# James B. Lennox & Associates Inc.

RE: Site Plan Control Application – 91 Holland Avenue

Please see our responses to the City comments below in red.

.2 LANDSCAPE PLAN

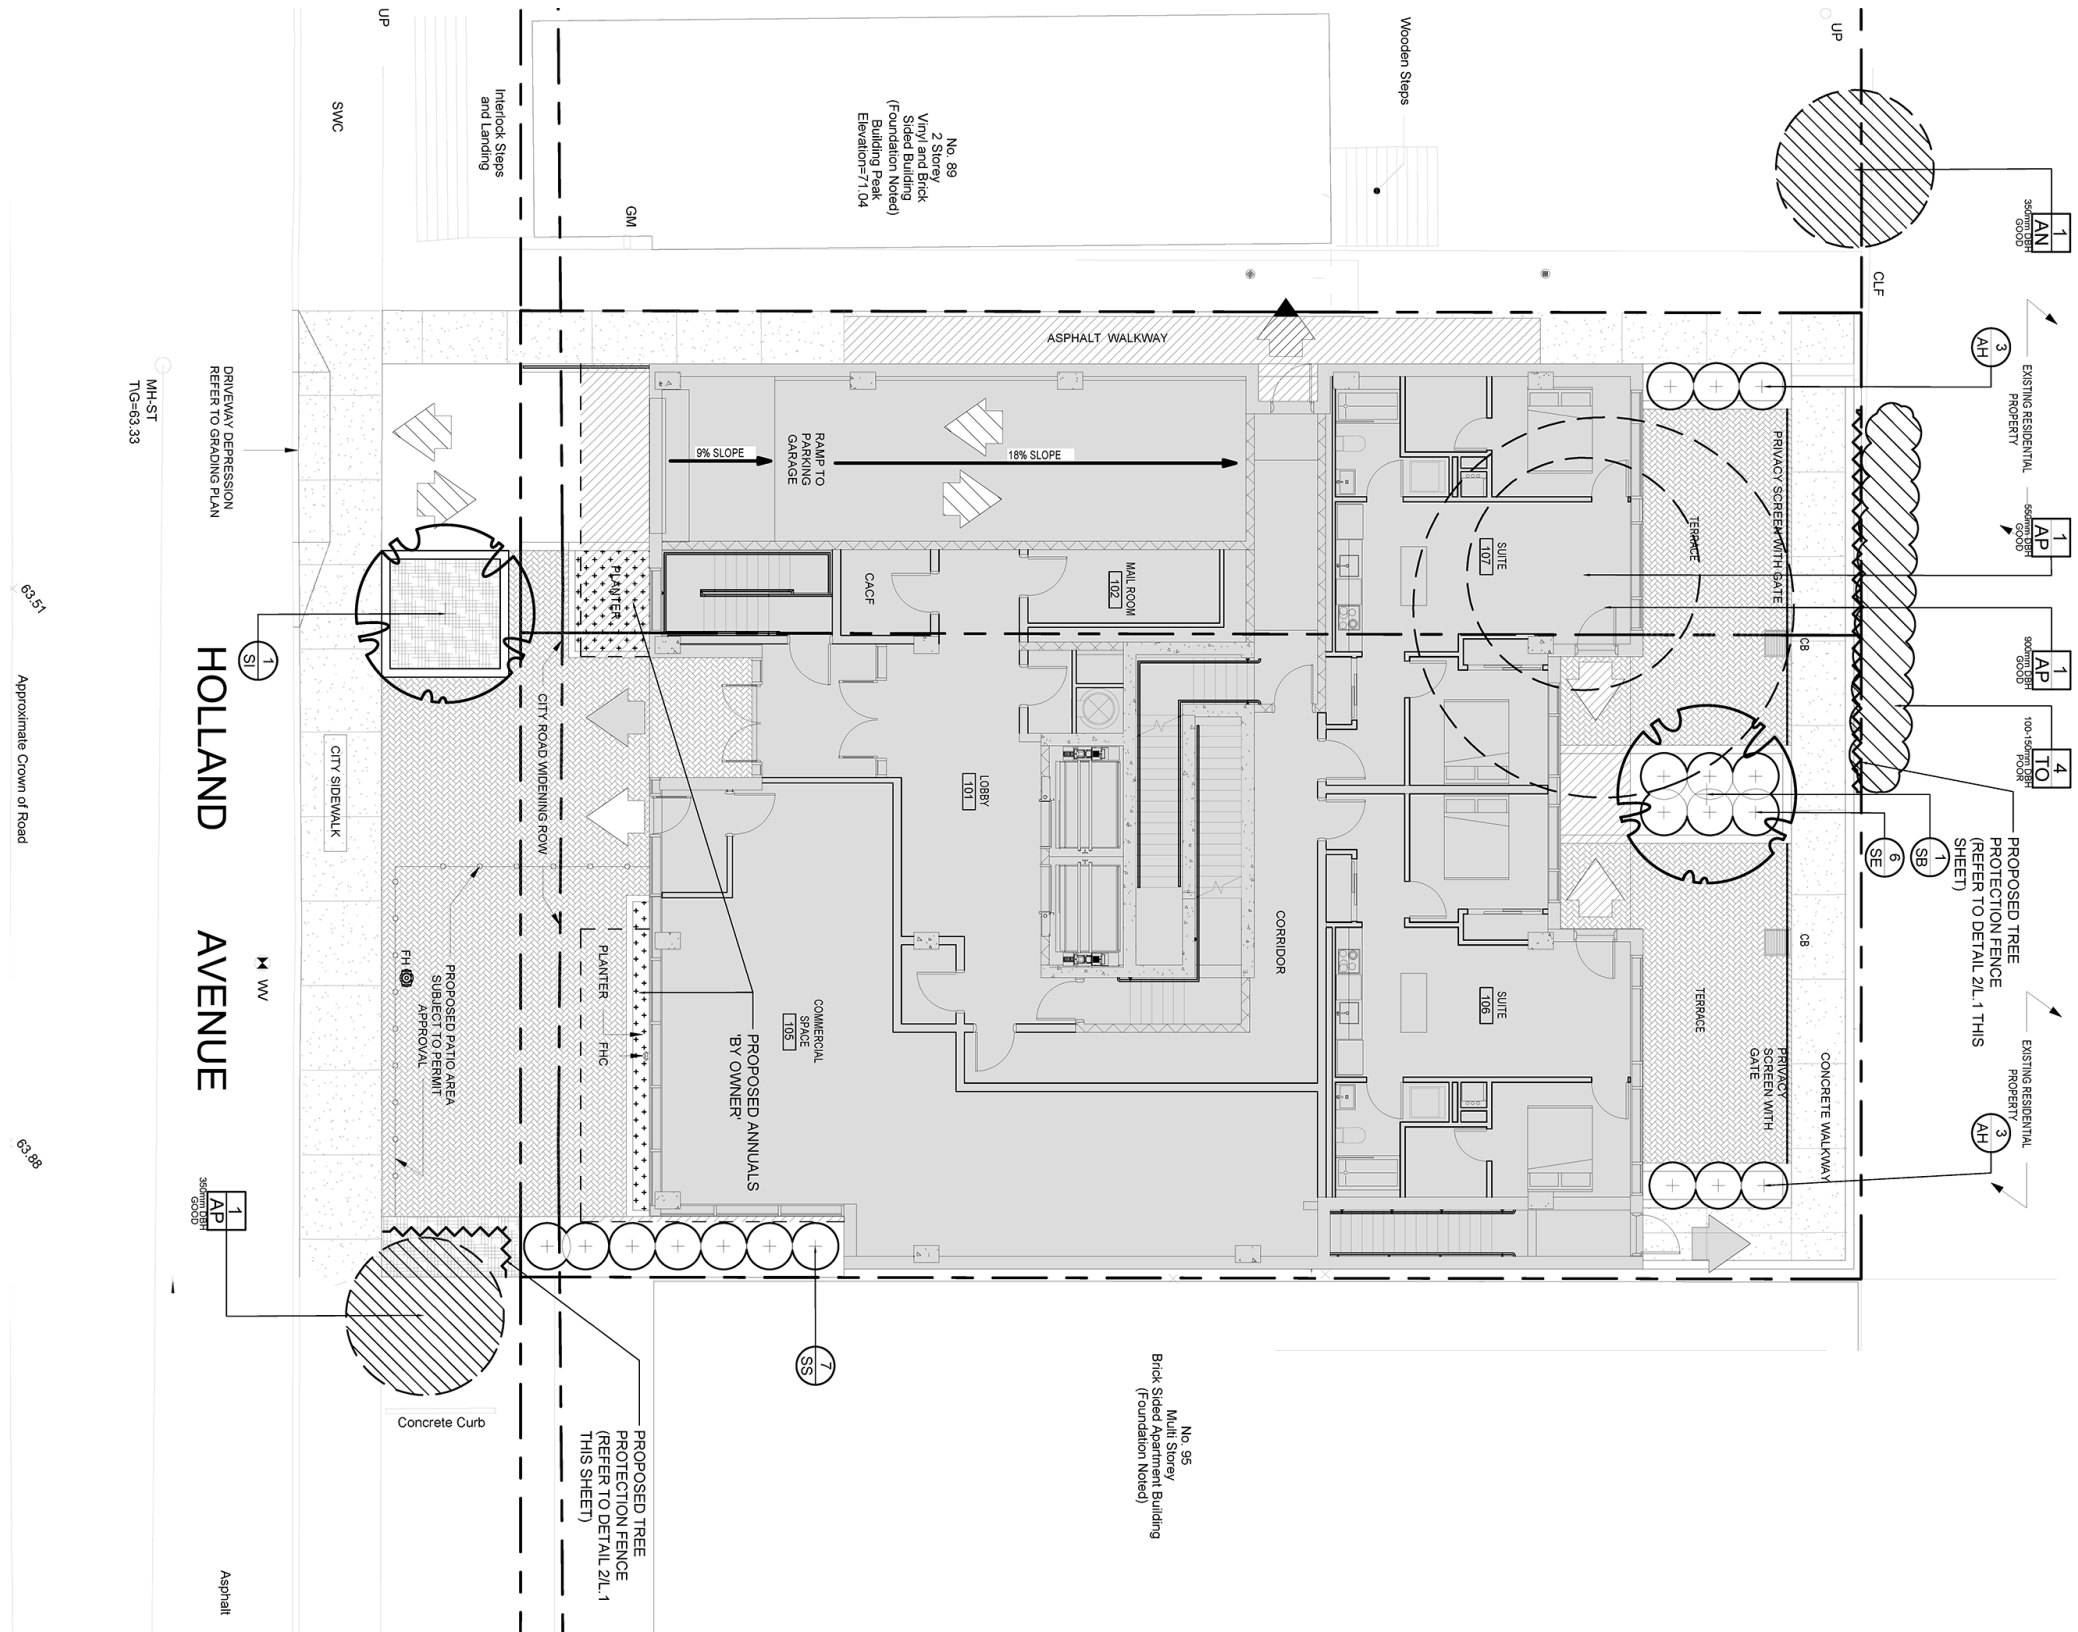
6. Please find ways to include more softscaping in the front yard. Perhaps a low planting bed next to the garage entrance. Please provide landscape plan with this. **The size of the proposed planter has been more than double in area from 2x2m (4 sq. m) to 3x3m (9 sq. m).**

14. What are the proposed soil volumes for the 2 trees? **The soil volume for the tree in the rear yard is 15.5 cu. m and the soil volume for the tree in the front is 13.5 cu. m based on a 1.5m depth.**

15. Street keeper locusts have a projected height of 45' and canopy spread of 20'. Therefore this should be considered a medium sized tree species. This narrow species appears more suitable for the rear yard planting. Please replace the front yard locust with a larger tree species. A Silver Maple or bur oak may be suitable species for the challenging environment. **A 60mm cal. Silver Maple (Acer saccharinum) has been proposed where the Street Keeper Honey Locust was proposed previously.**

16. The planting pit for the front yard tree is a serious concern for soil volume. The planting pit appears to be 2mx2m which would only provide 6 cubic meters of soil. If the front entrance must be so heavily hardscaped, soil cells will be required to provide a sufficient growing environment (25-30 cubic meters) for the street tree. Otherwise reducing the hardscaping to include additional soil volume for the tree will be required. **The hardscaping has been reduced and the planter size increased to 3x3m would will provide a soil volume of 13.5 cu. m at a 1.5m depth.**
